CITY OF ALBUQUERQUE

**RE: McMahon Property
Grading Plan
Engineers Stamp Date: 6/15/17
Hydrology File: A11D016**

Based on the information provided in your submittal received on 6/16/17, the Grading Plan is not approved for Grading Permit. The following comments must be addressed prior to approval:

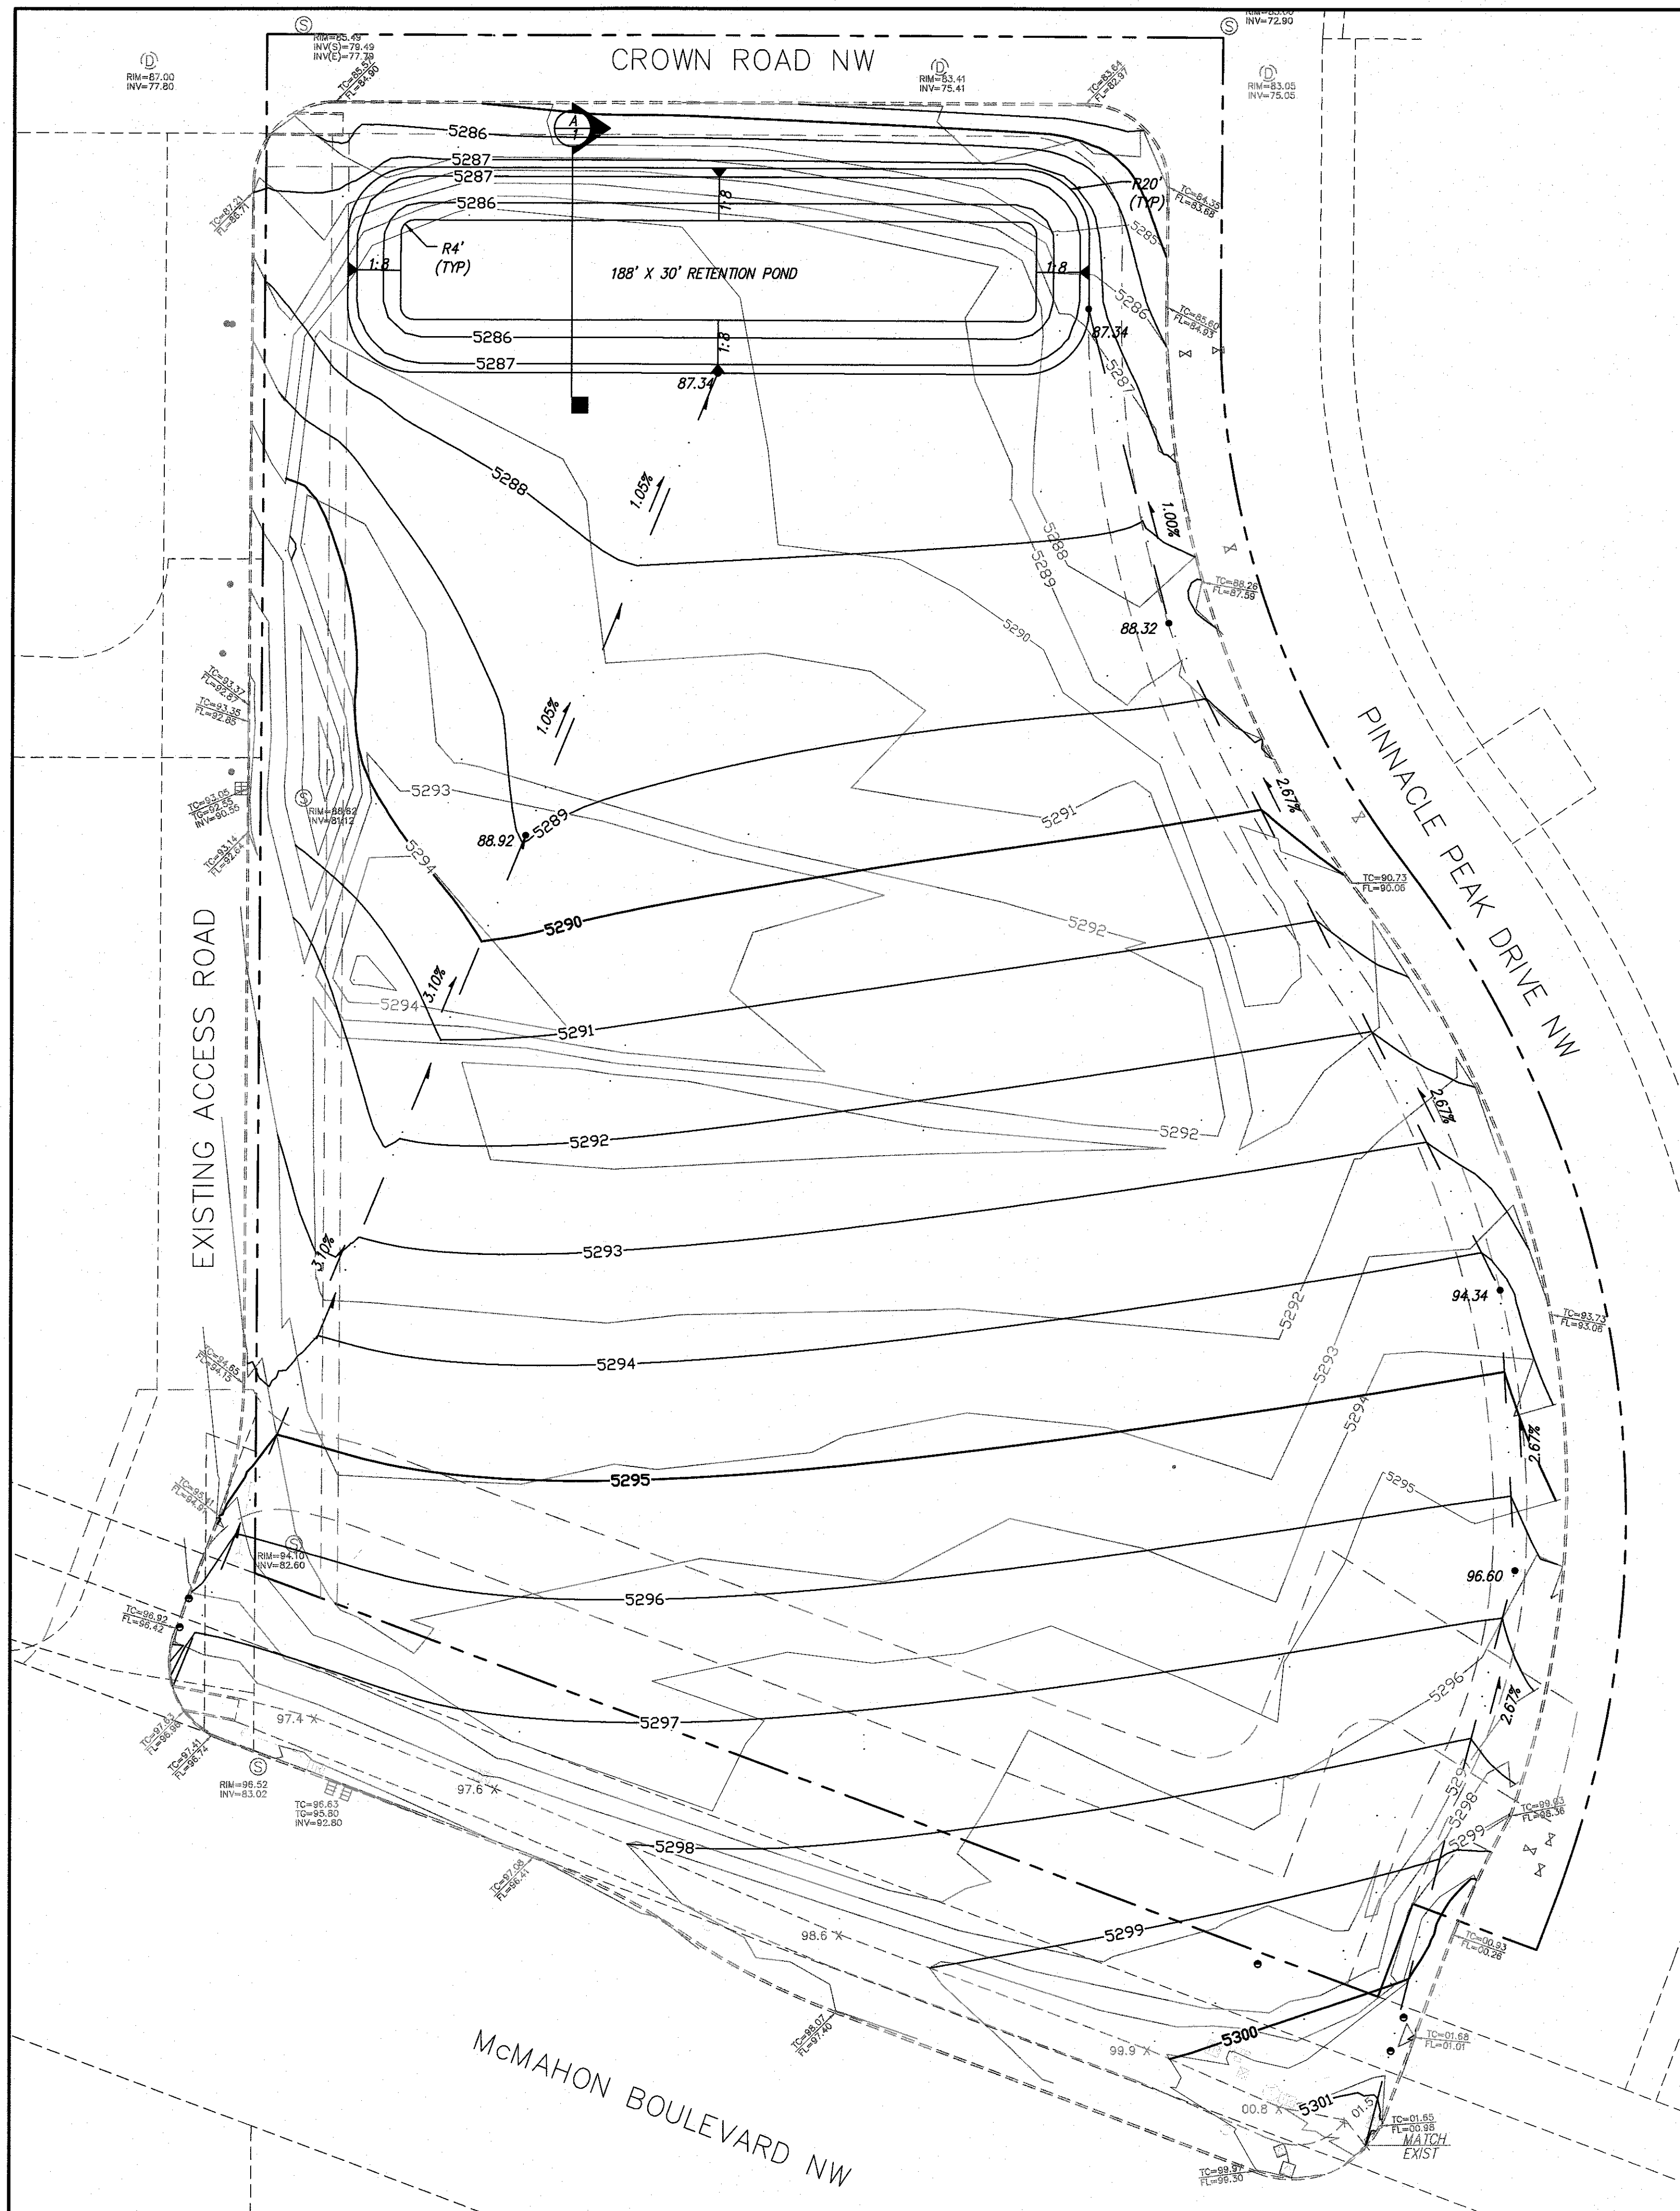
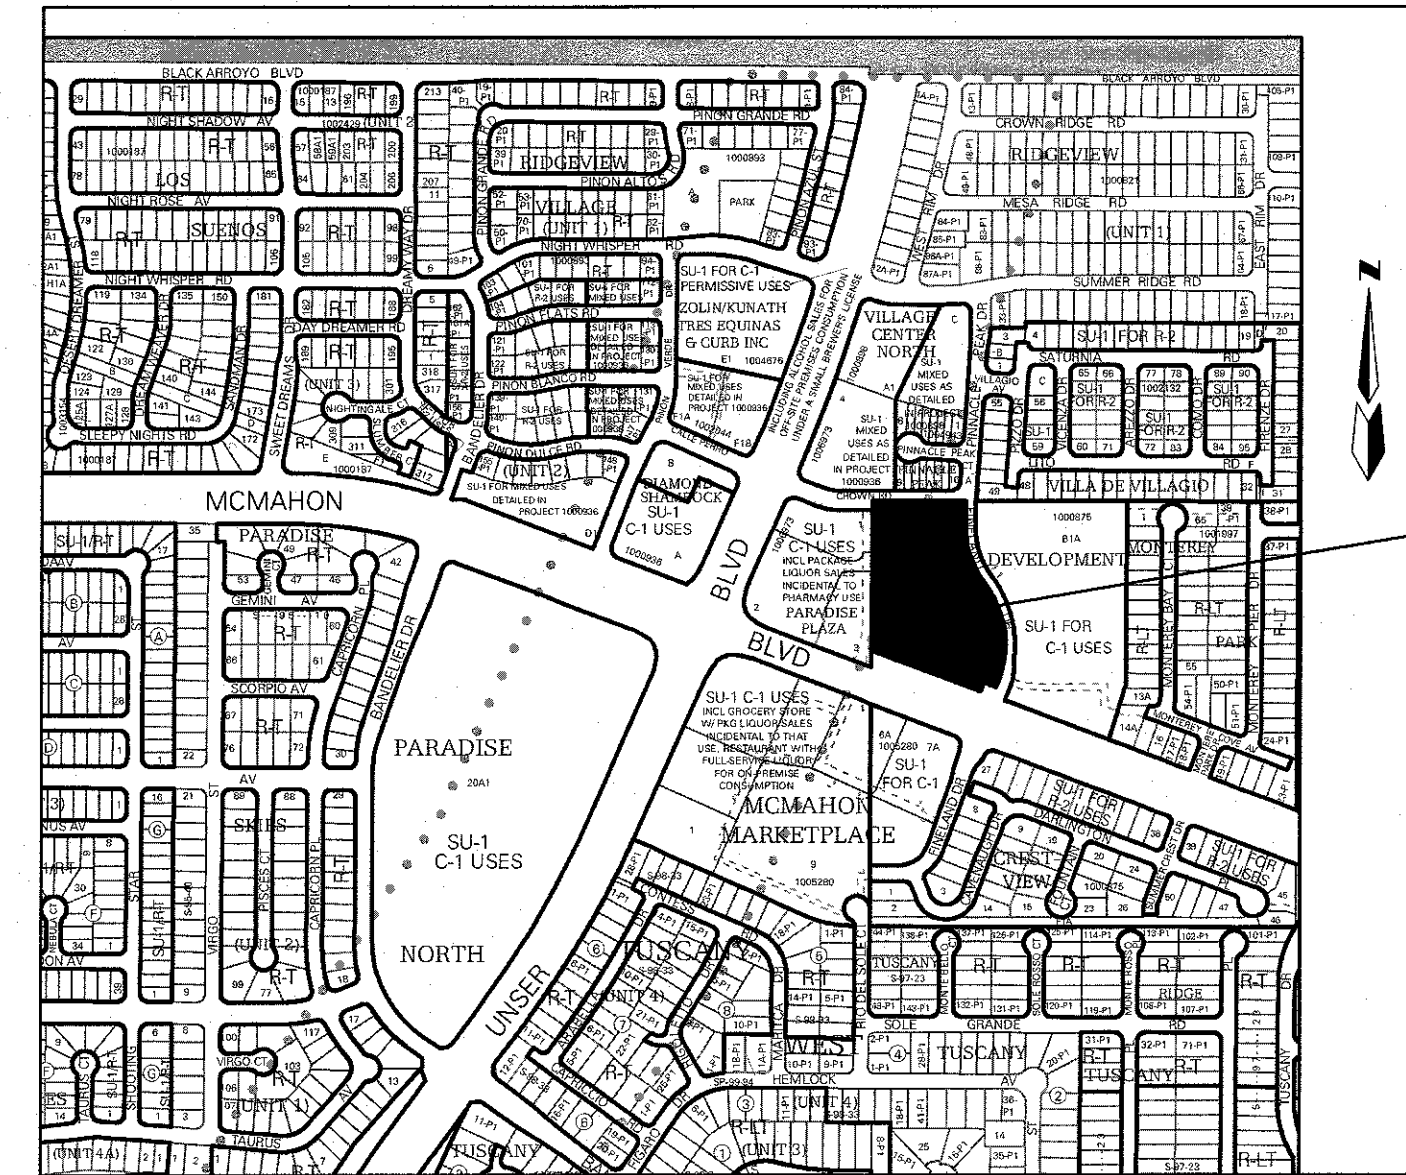
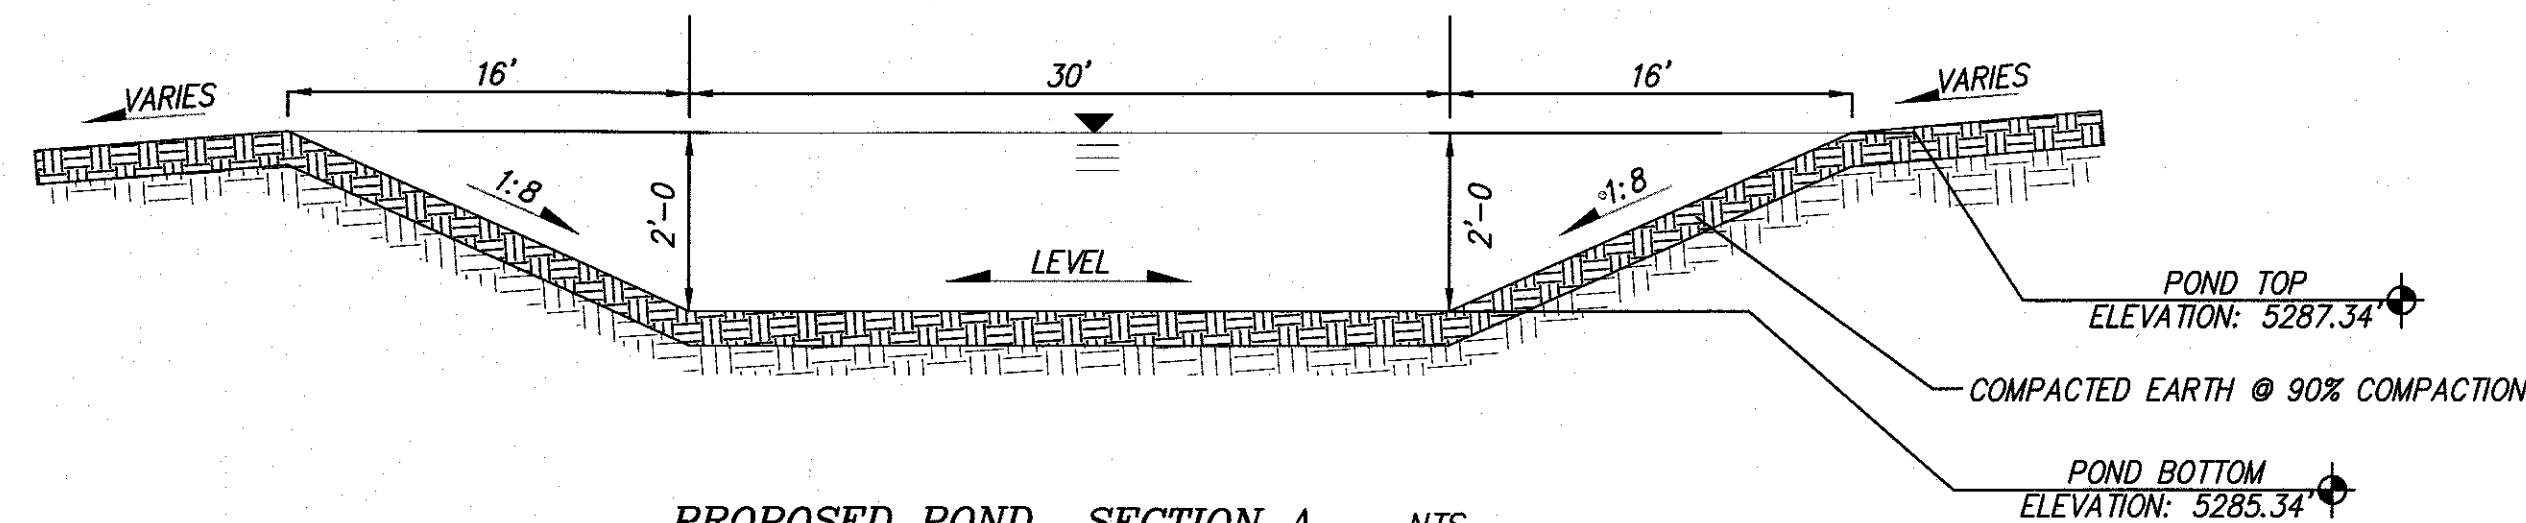
1. Correct labeling on drainage parameters (P10yr, V10yr).
2. The pond will need an armored emergency spillway sized for Q100. Alternately, the pond can be reconfigured to eliminate the embankment between top-of-pond and the top of curb on Crown Road.
3. The contouring adjacent to Pinnacle indicates that a high area will be created, rather than a swale. Provide a swale to prevent rilling and erosion onto Pinnacle.
4. A Private Facility Drainage Covenant is required for the pond.
